MR & KM Hussey

Deadline 3 Response.

PINS Reference EN010137 Mona Offshore Wind Farm
Interested Party numbers MNOW-S57019 & MNOW-S57018

UPDATED INDICATIVE MAIN TEMPORARY CONSTRUCTION COMPOUND LAYOUT NOT TO SCALE

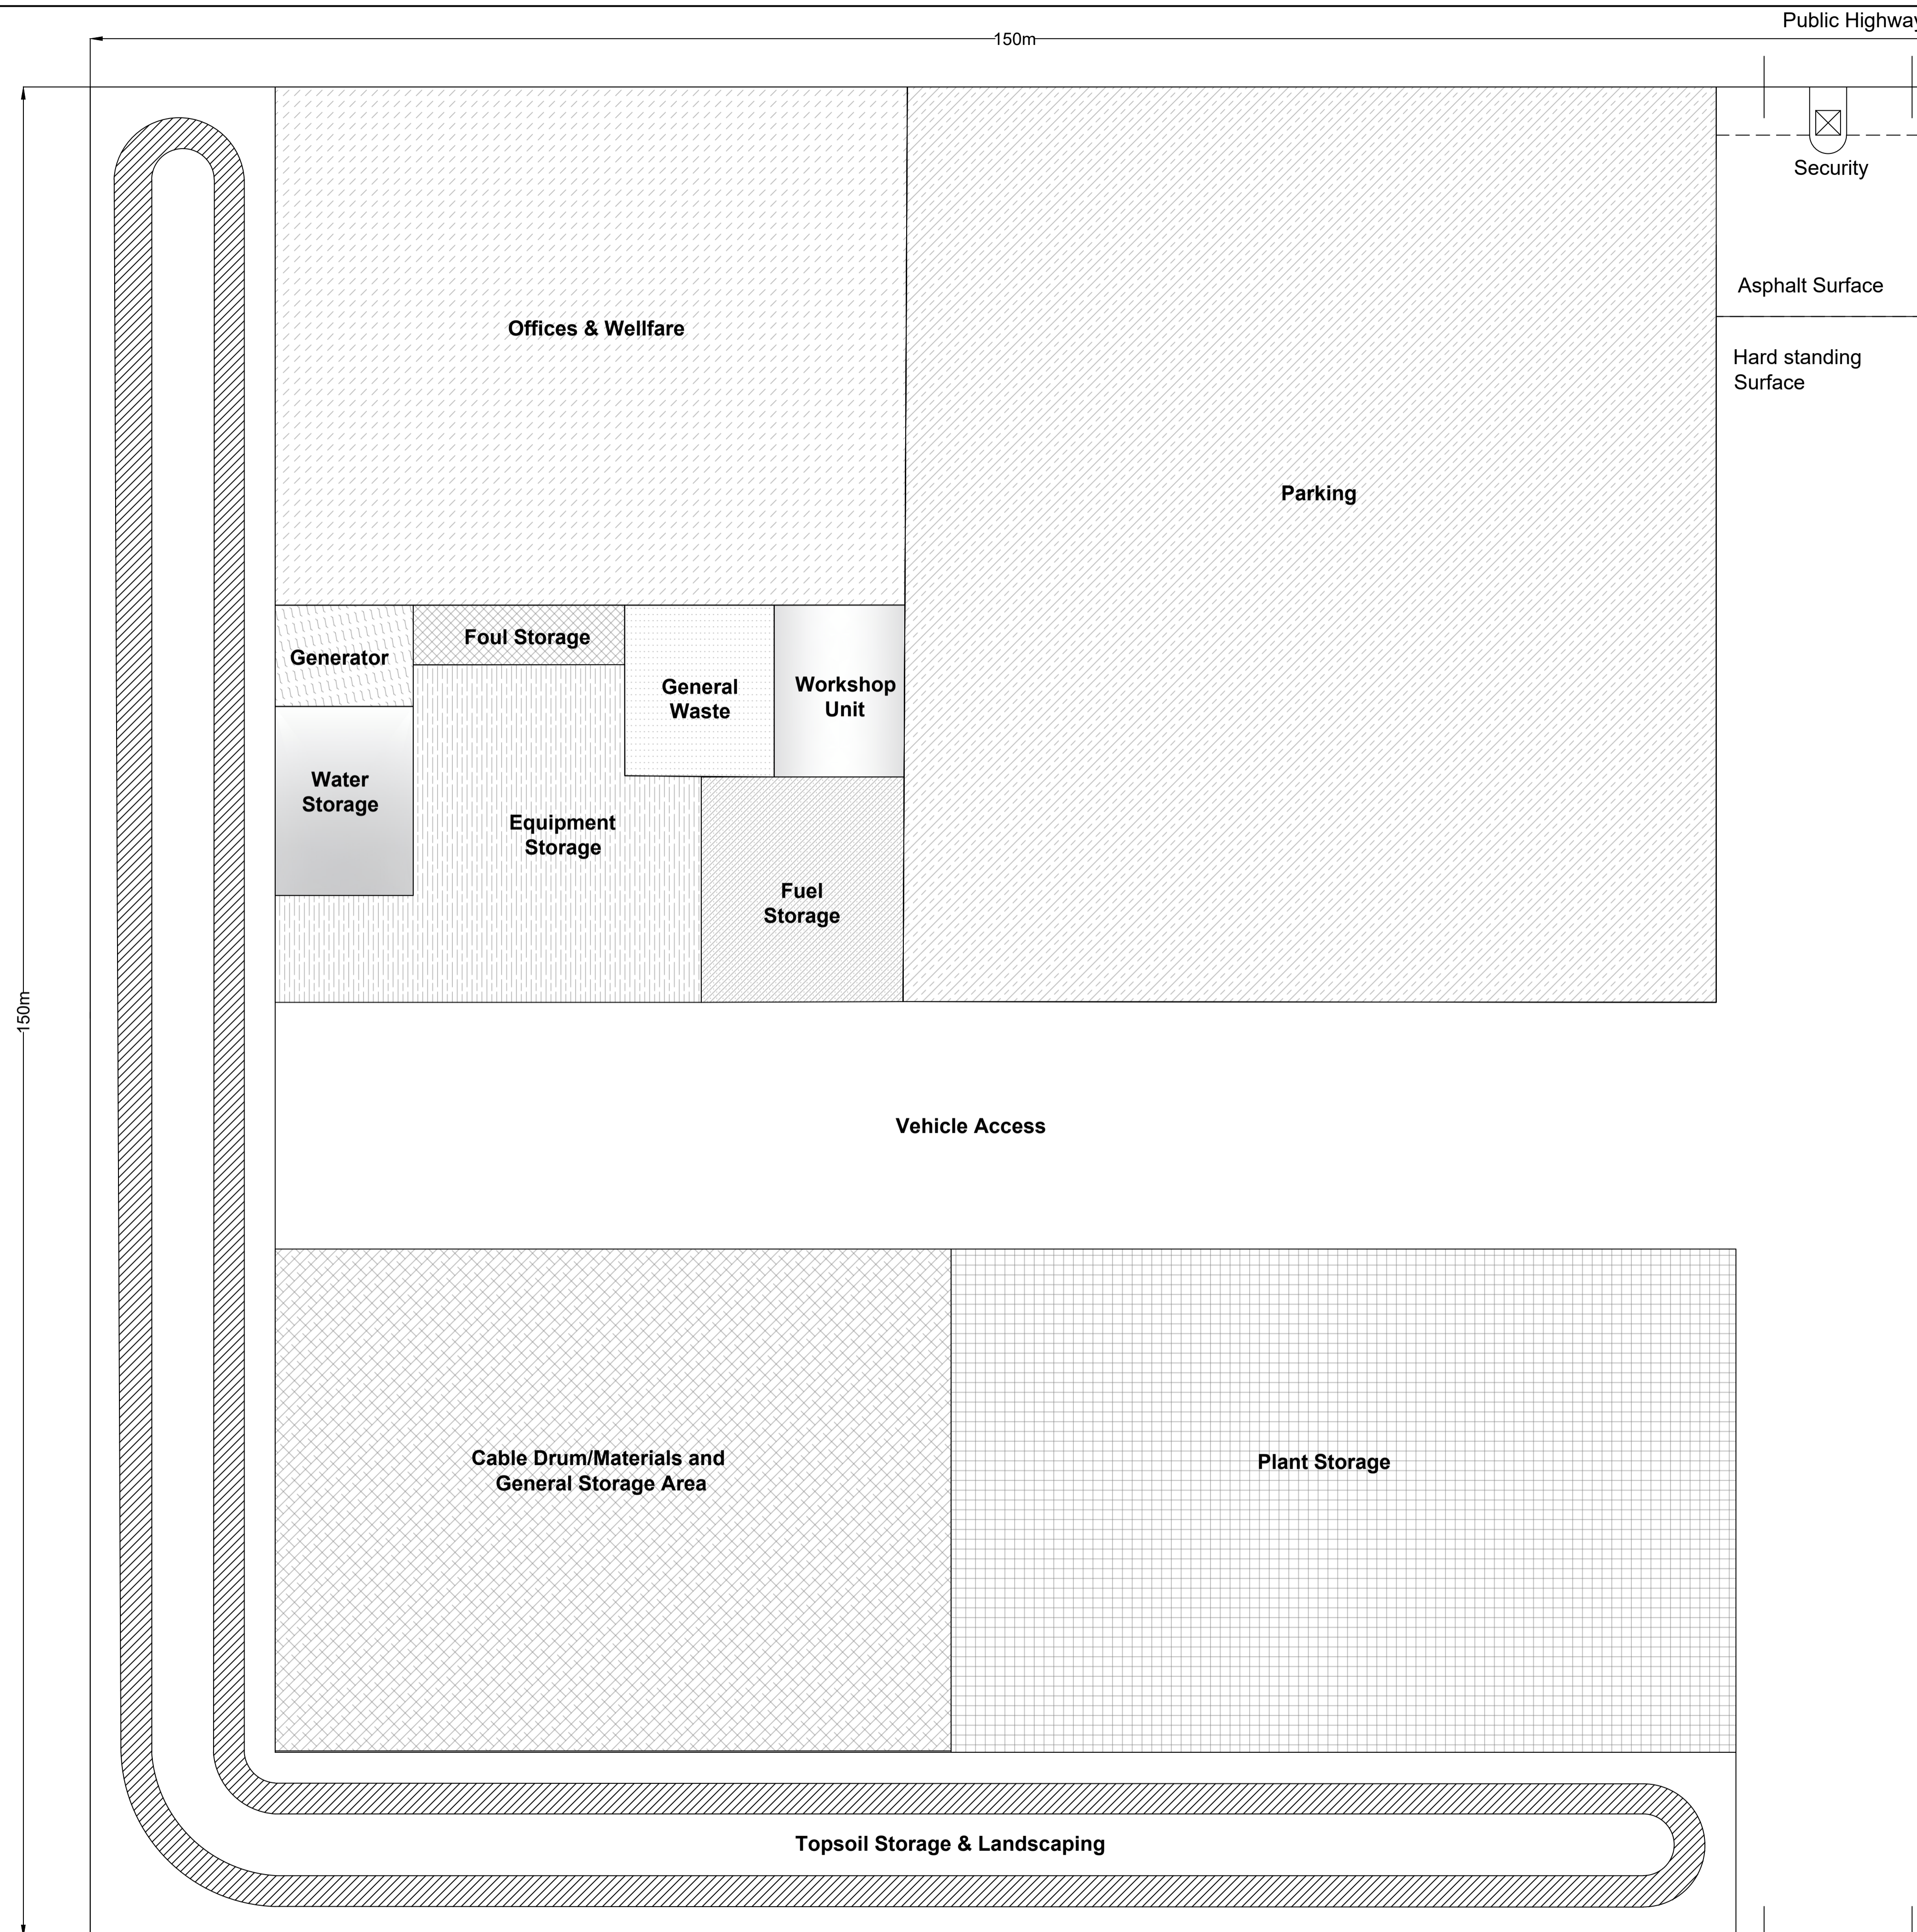
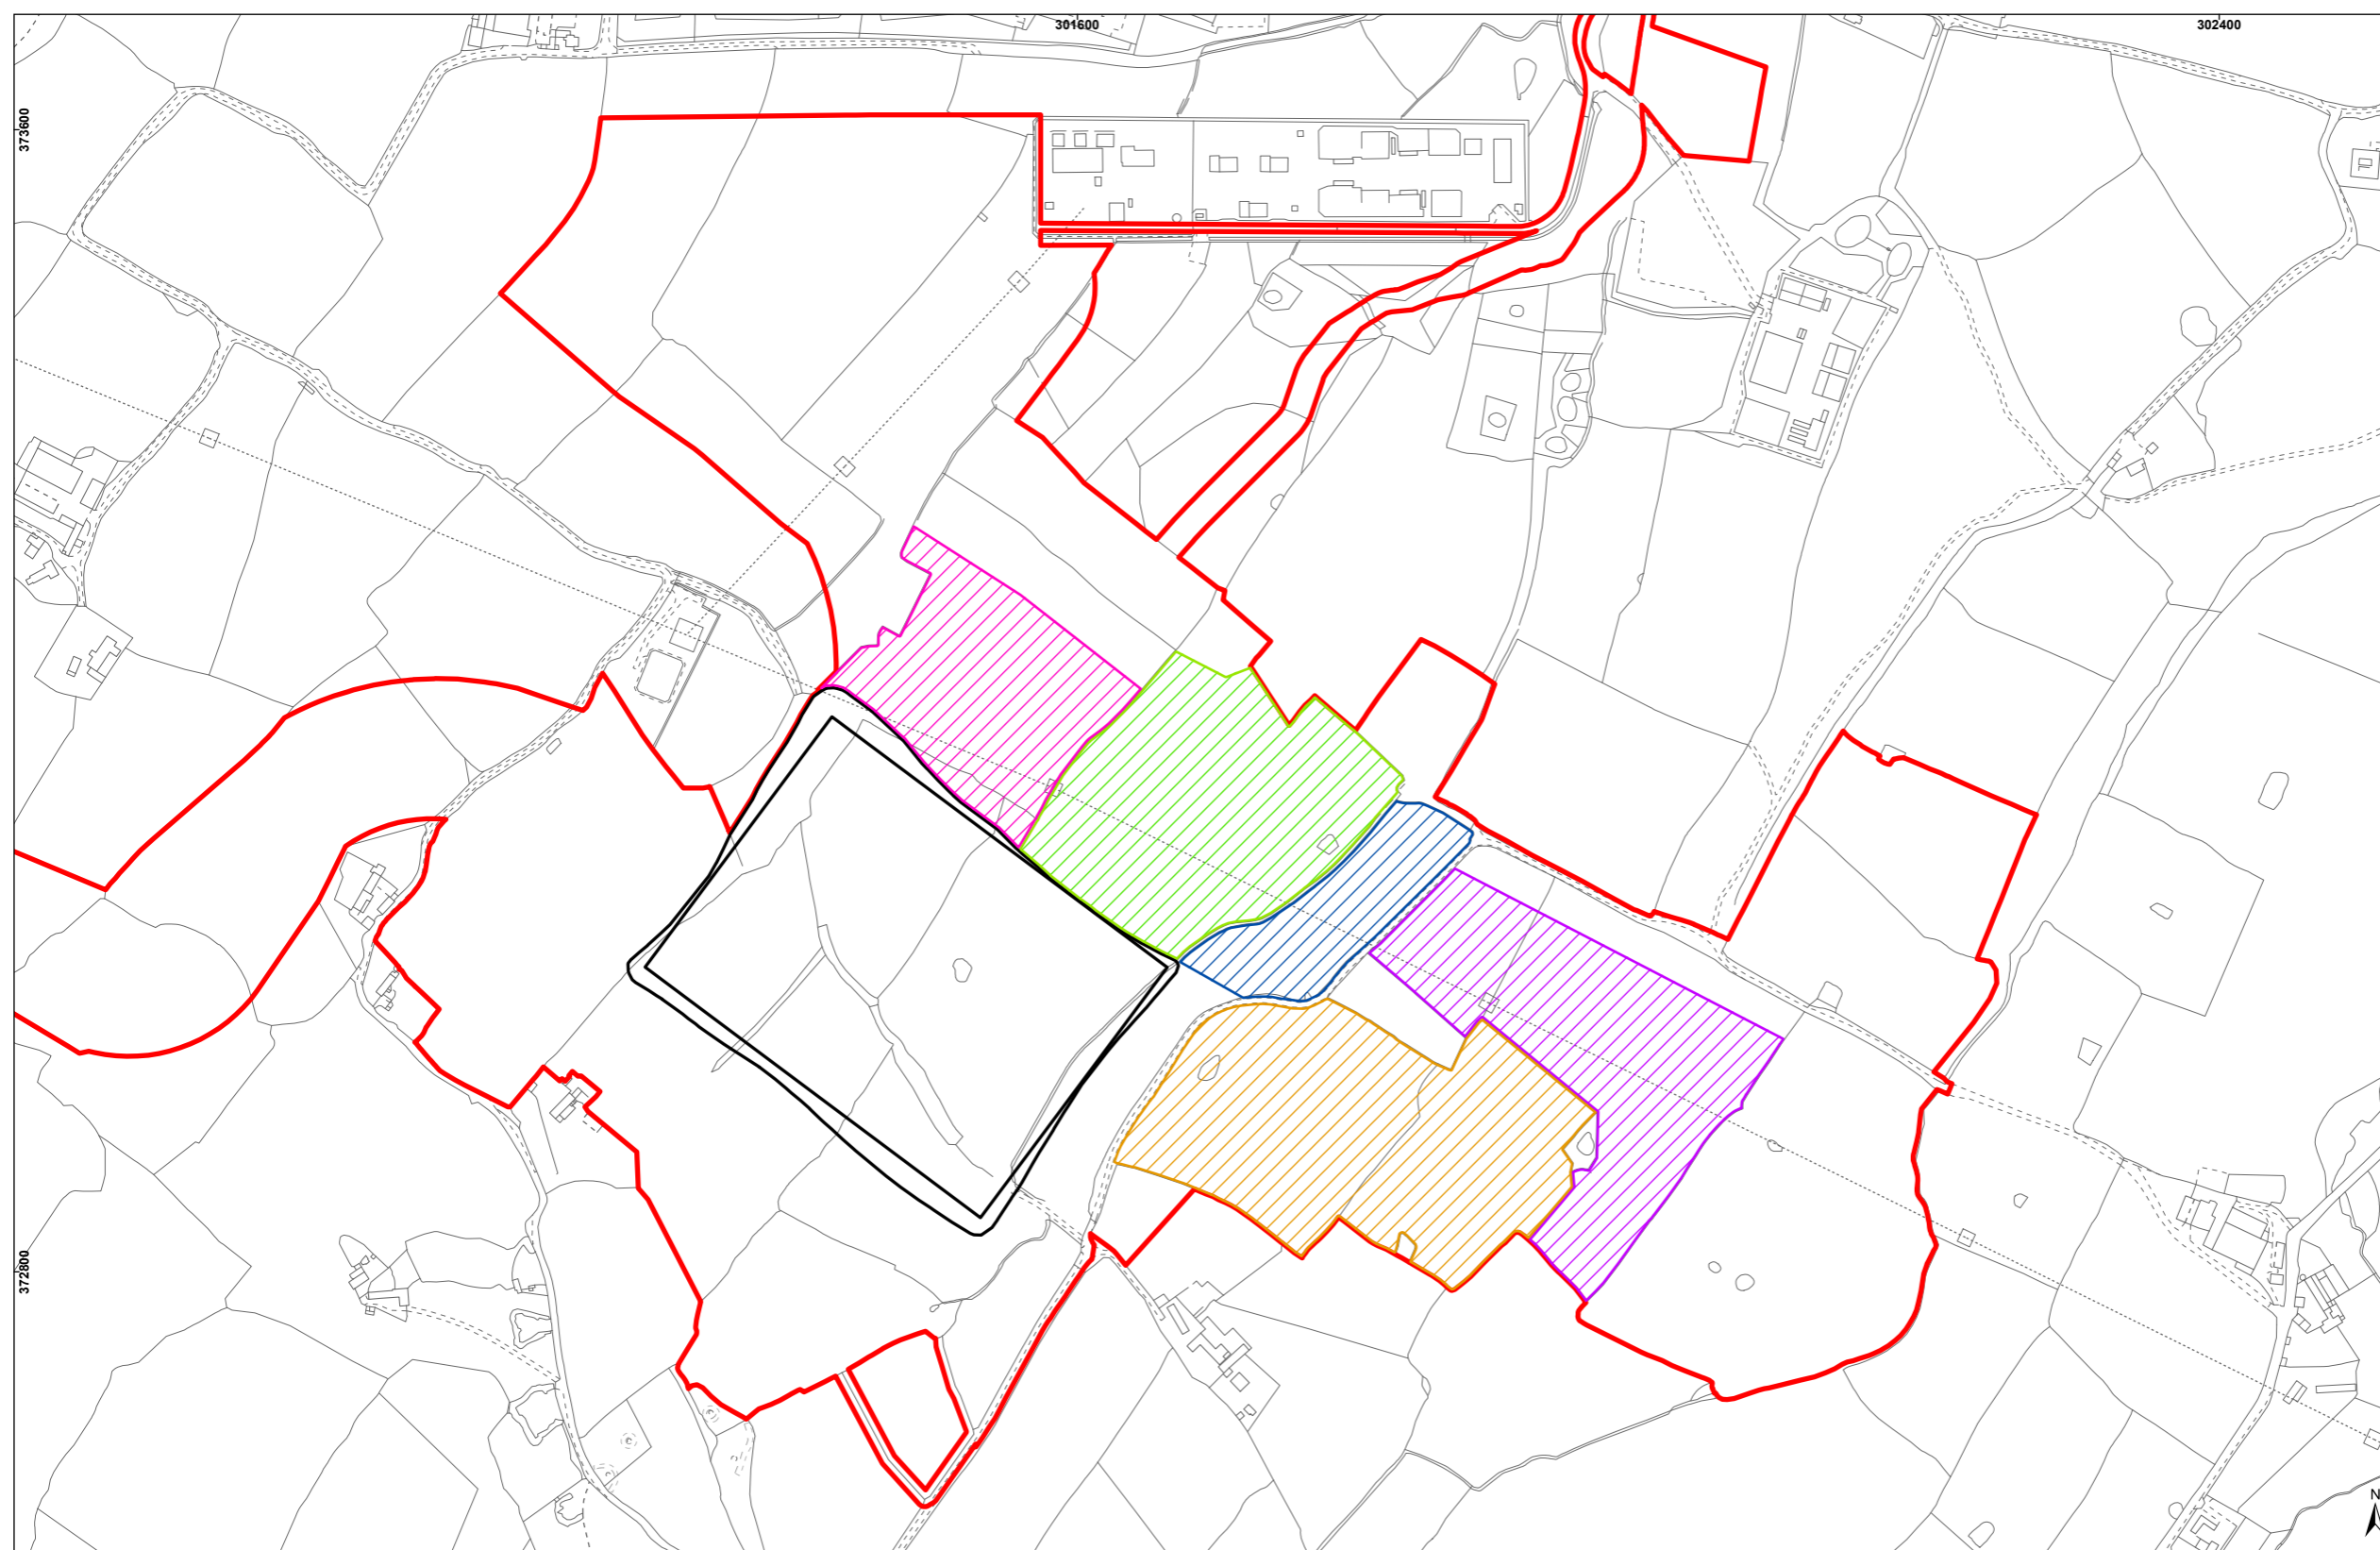
- Noise level Predictions
 - In questioning actual distances used in the model for our property from each construction activity the applicant has referred us to the location of the temporary construction compounds in the vicinity of [REDACTED] as shown on drawing number 12079-0712-01 in ES Volume 7 Annex 9.2 (APP-179), whilst at the same time referring us to:-

Below is part of the drawing number as referenced by applicant with temporary construction compounds indicated by pink cross hatched areas , the closest to [REDACTED] being top centre of this drawing by the wording Mawr

It appears from this drawing combined with the responses made by the applicant at deadline 2 and the statements in APP-179 that in assessing the noise impacts on [REDACTED] the distance used in the modelling (which is a significant influencer) was from the nearest temporary construction compound to the boundary of our property.

- This would mean that distances used in the modelling for [REDACTED] would be approximately 400mts which is significantly greater than:-
- For e.g.
 - Substation construction would be <200mts

- Using this methodology of distance from temporary construction compounds for modelling would significantly under estimate the true likely impacts on ourselves, bearing in mind that where the distance from the noise is halved then an increase of 6dB is likely so that it is much more likely that our true impacts will exceed threshold values consistently throughout the many years of construction.
